Application Reference: P/107/25/DOC Site Name: Land West of Hook Lane Pagham PO21 3PB	Initial Issue Date: 12/12/2025 Issue Date: 12/12/2025 Reviewer Reference: ADC/EXT4
--	--

Summary and Recommendation:

Condition 9: **Further information required**

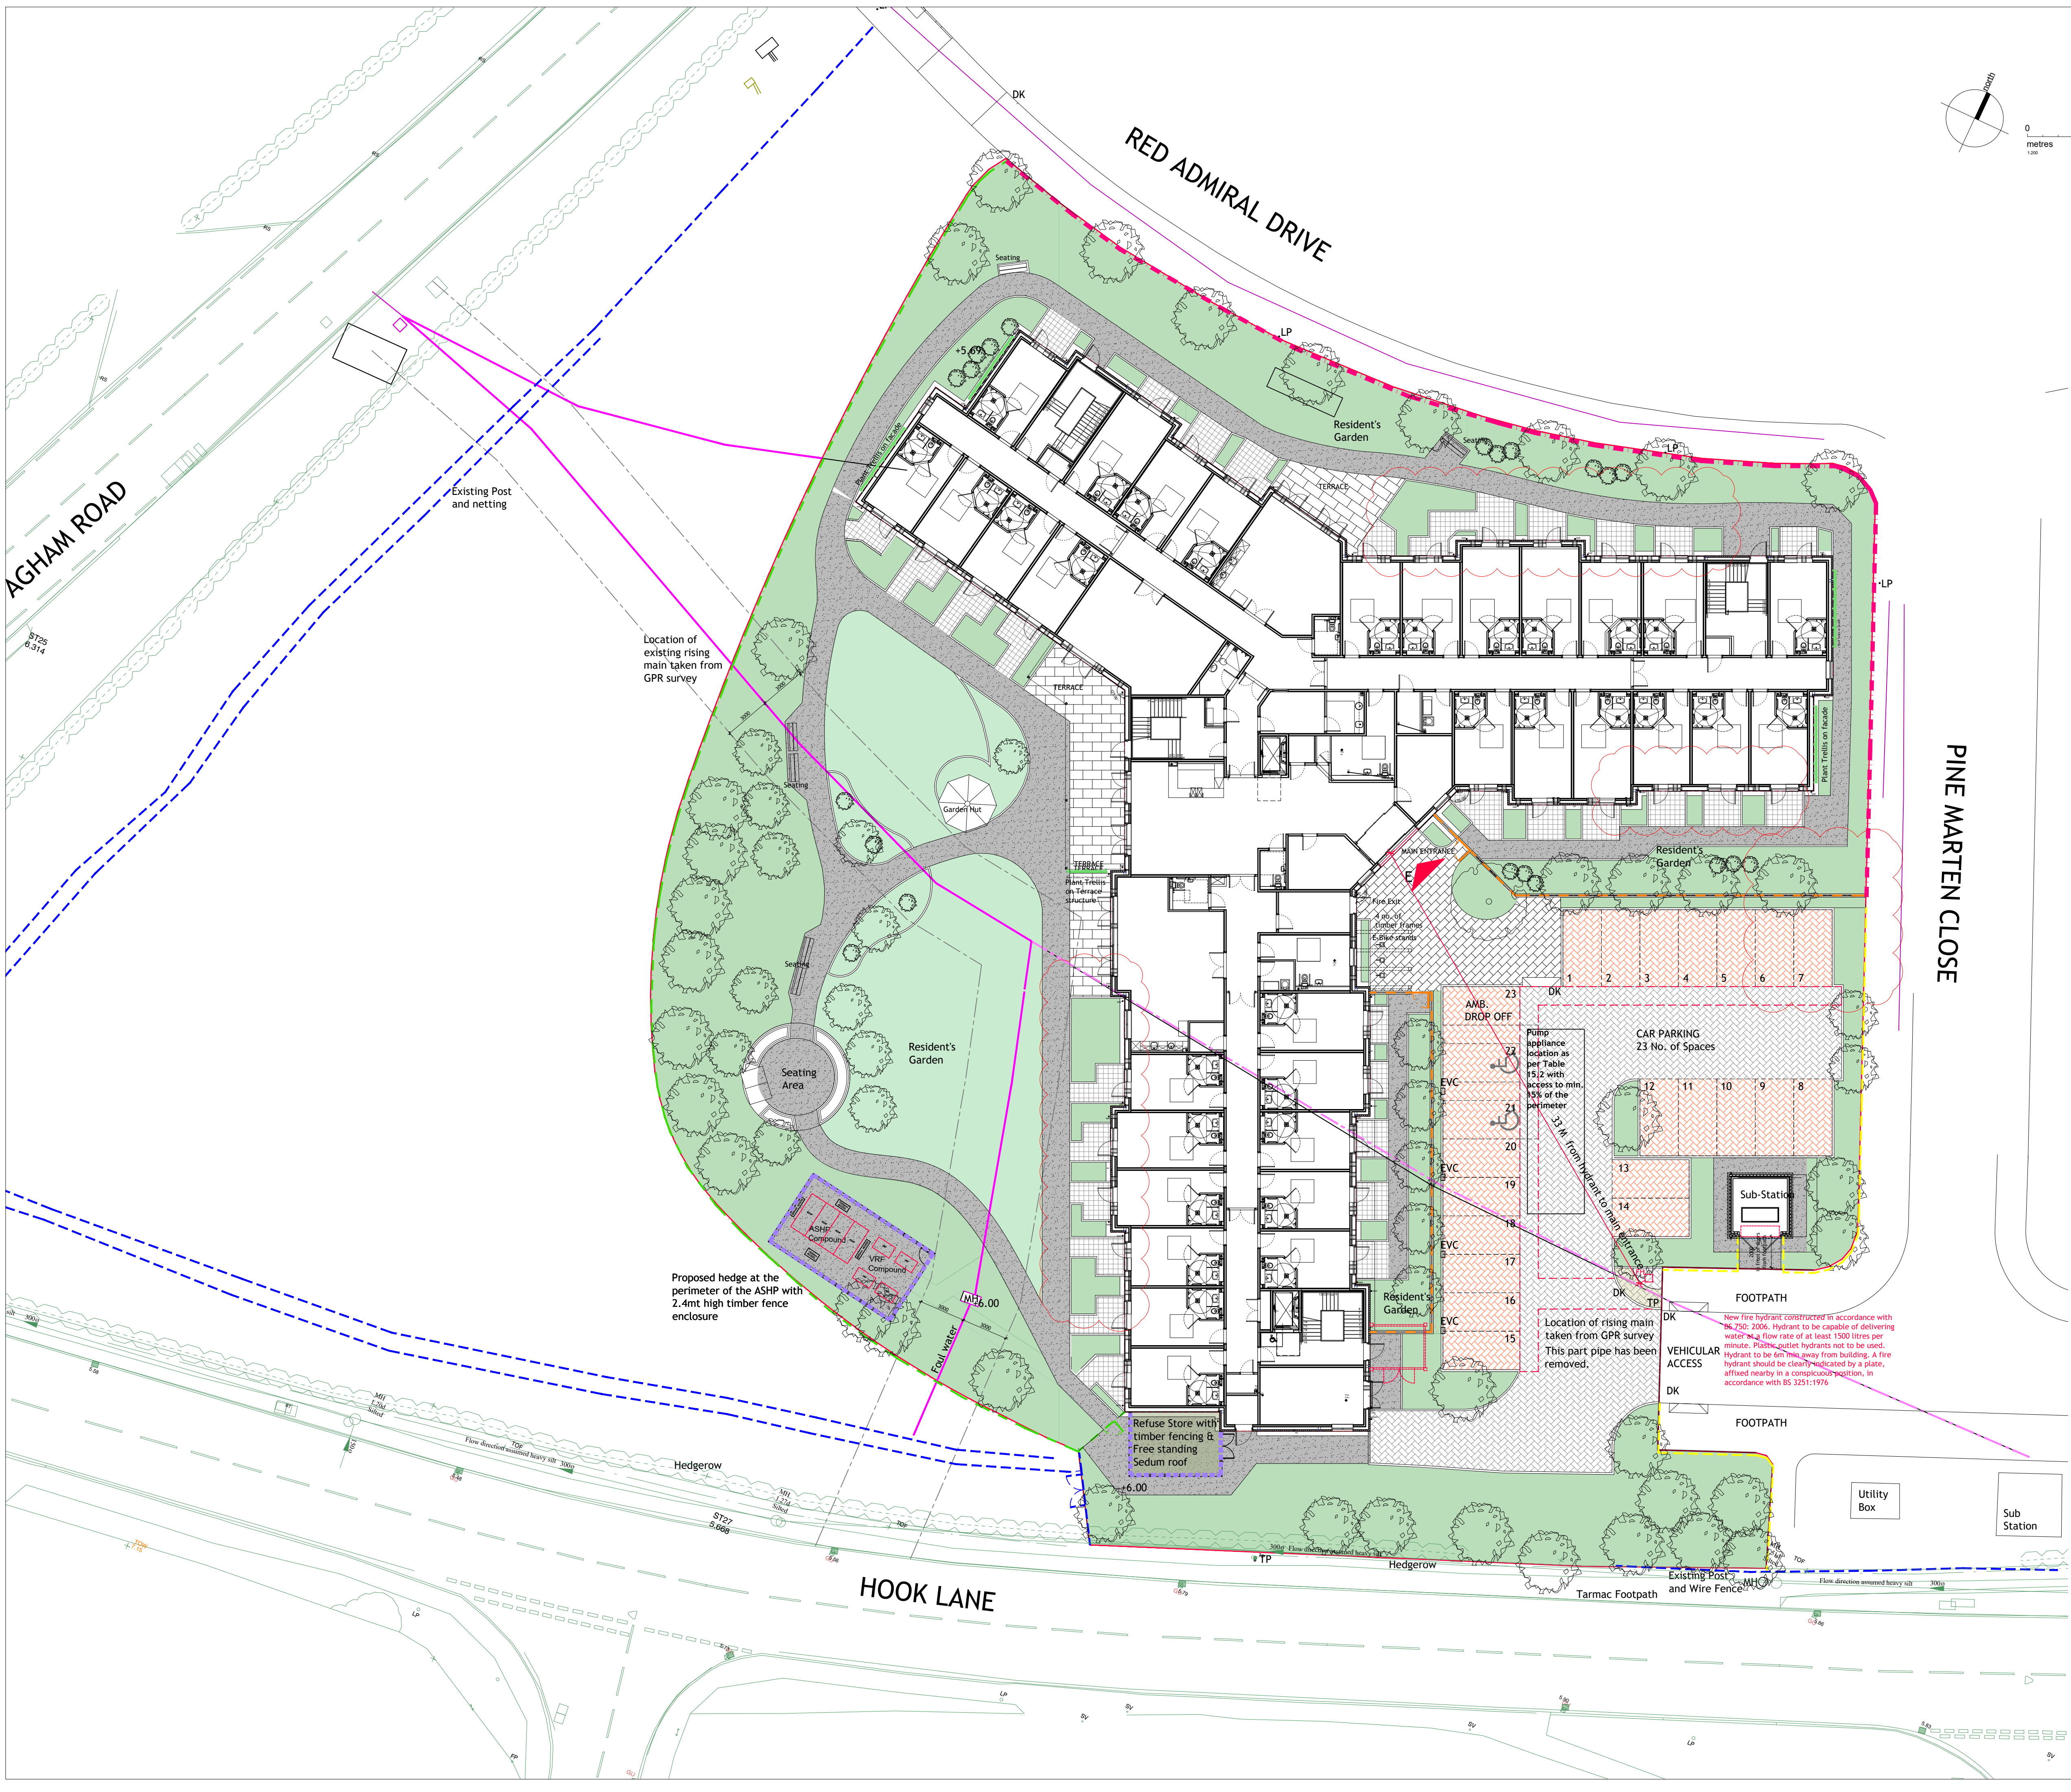
8	Detailed landscaping proposals are required to demonstrate that the landscaping and drainage proposals are coordinated. a) The indicative landscape proposal drawing shows a tree very close to tank ST1. Section A-A provided does not appear to represent this.  b) Provide information from the root barrier manufacturer and the tank manufacturer that the proposal is acceptable. c) Demonstrate that the tanks are structurally sufficient given the close proximity of the trees. d) Provide accurate cross sections showing that there is adequate space for the building foundations, foul	A. Rev C Calculations - Updated Drawings & Calculations. B. See Appendix G. C. See Appendix G. D. Updated Drawings & Calculations. See Appendix G. F. Updated Drawings & Calculations.	a. item now closed b. item now closed c. item now closed d. item now closed e. item now closed f. item now closed g. (New Item) there appears to be clashes on the proposed drainage runs and trees SW-IC03.01 to SW-MH-02.01 and SWIC-01.03 to SW-IC01.04	See revised drawings in Appendix F showing no clashes with trees.	Item now closed

A			
Rev.	Description	Date	Initials
INFORMATION			
Client			
SIMPLY UK			
Location			
HOOK LANE, PAGHAM, PO21 3PB			
Drawing Title			
ROOF DRAINAGE FLOW ROUTES AND SQUARE METERAGE LAYOUT			
Date	Drawn by	Scale	Checked by
OCT 24	JPC	1:200	LC
Project Ref.			
9418			
Dwg. No.			
C010			
Rev.			
A

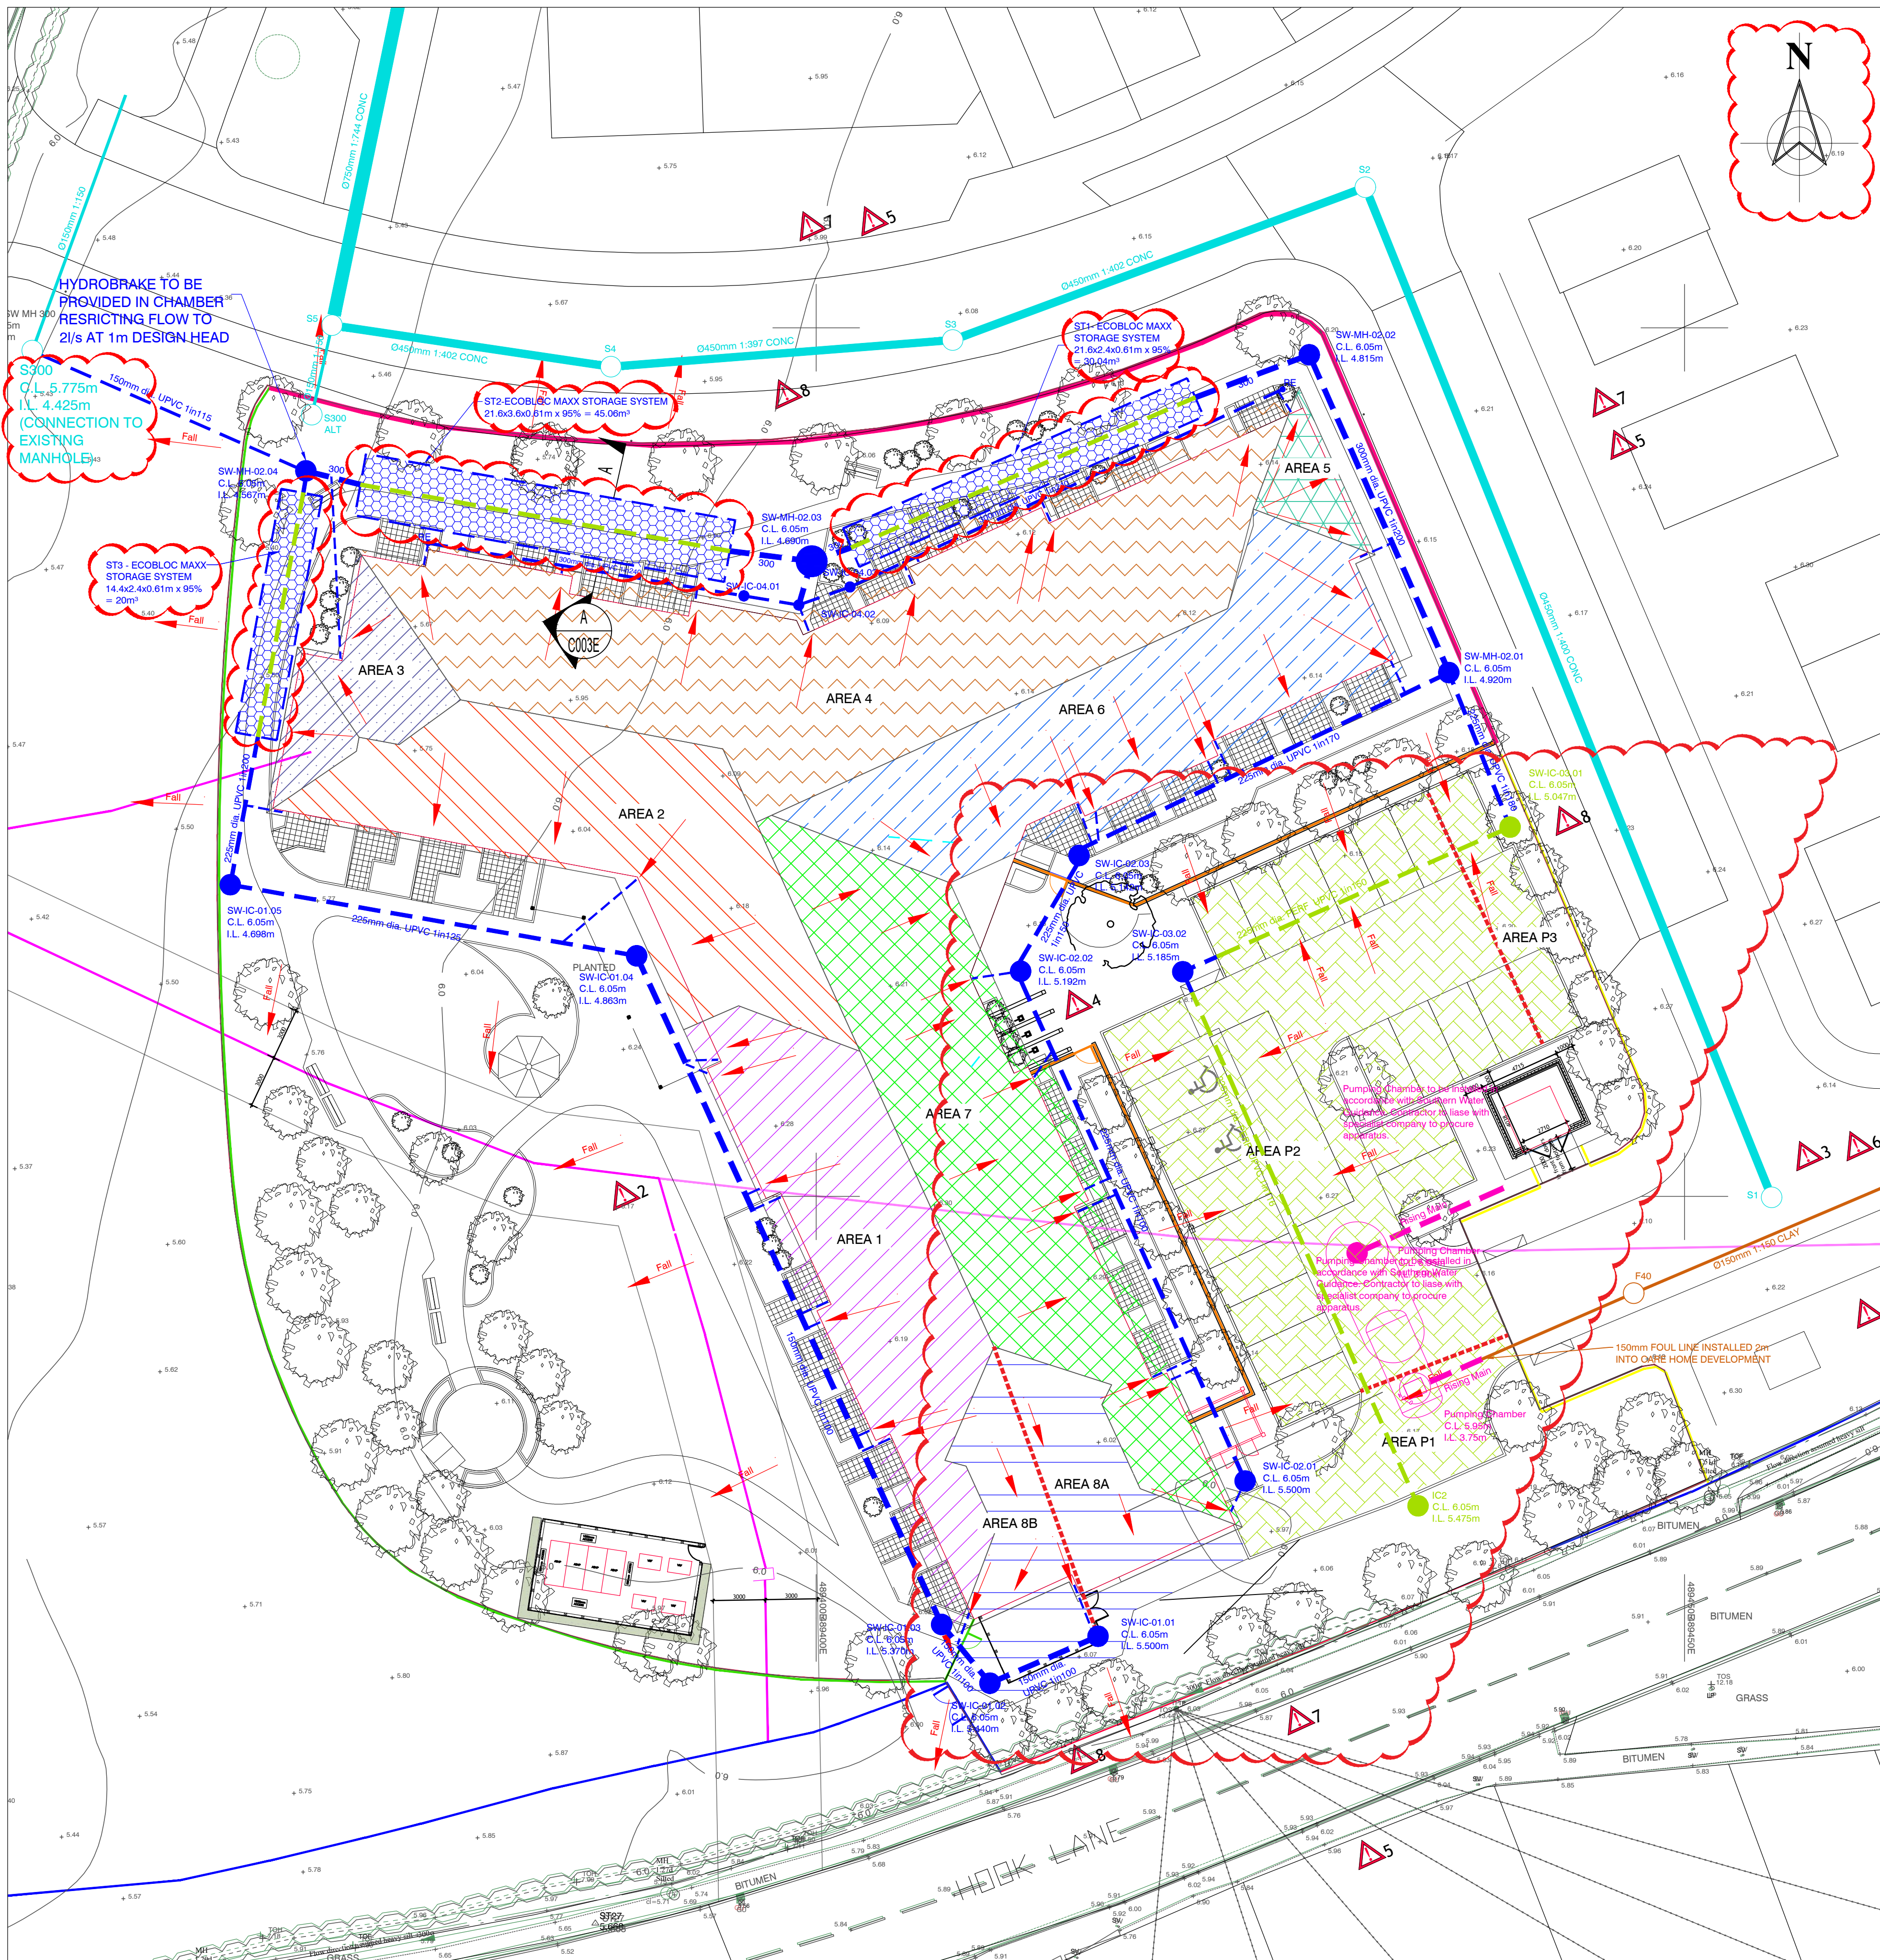
j) The calculations do not include results for all required design storm events k) The calculations do not include the FEH22 point descriptor information. Ensure calculations are consistent with the drawings and show all information				
4	Whilst a catchment drawing has been provided it does not clearly split the catchment into nodes. eg. a) Area 8 catchment is collected by 2 nodes. b) Similarly, whilst the total permeable paving area is shown, it is collected by 3 nodes. Provide a catchment drawing demonstrating the catchment for each node in the calculations	A Updated Drawings & Calculations. B Updated Drawings and Calculations	Noted, Item is now closed		
5	The design proposals should clearly demonstrate its relationship with the surrounding Bellway's development, especially as its proposing to	5. This was provided in Rev. A calculations. See Appendix E.	The information provided in Appendix E indicates that the peak discharge from the site should be restricted to 1.89l/s whilst the proposals are to	We have appended revised calculations in Appendix B and drawings showing the 1.89 l/s and not 2 l/s as requested.	The calculations in Appendix B dated 07/11/2025 still appear indicate 2l/s outflow at outfall MH02.05 for the M100 +45% event. Please
